**Case Officer:** Linda Griffiths

**Applicant:** BDW Trading Limited

**Proposal:** Discharge of Condition 20 (Site Environmental Management Plan), 21 (management, storage and/or disposal of spoil), 25 (archaeological Written Scheme of Investigation), 26 (on-site renewable energy provision) and 27 (34 space public car park) of 15/01326/OUT

Brand: BARRATT / DAVID WILSON HOMES	Rev:	Description:	Date:
Range: 2010 / 2016 & -5 / -7			
Title: Generic Standard (Hired) Site Compound			
Detail No: DB-SD13-017			
Drawn: GDT	Checked: GDT	Scale: 1:100	Date: Aug, 19

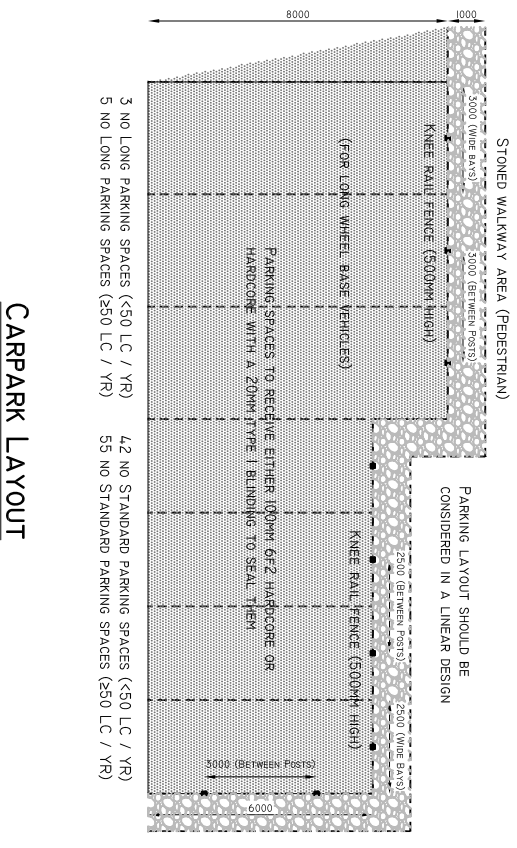
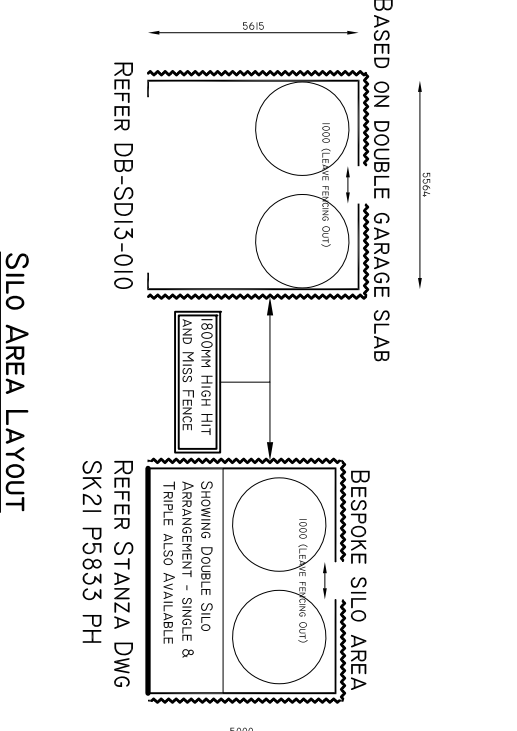
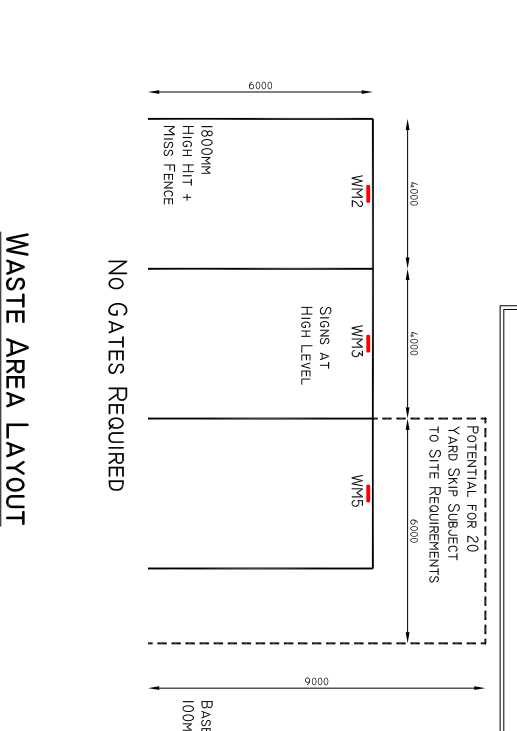
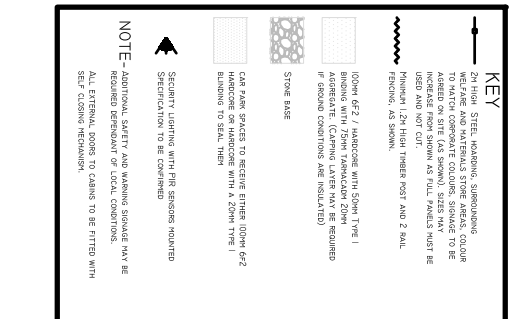
5.1 Condition 20 – Construction Environmental Management Plan (CEMP) – the original CEMP was deemed inadequate in terms of proposed delivery routes to the site, no construction from White Post Road to the south of the site, the route needed to be clearly illustrated and the need to ensure deliveries are made outside of peak hours, particularly having regard to the adjacent school site. There were also concerns

raised that the compound was initially shown within the open space and on the site of the main attenuation basin. These deficiencies have all now been addressed in amended proposals, which are considered acceptable.

Revised submissions 7942/CTMP/01 Rev C; compound layouts DB-SD13-16A and DB-SD 13-017 and BOD.TMP-01.
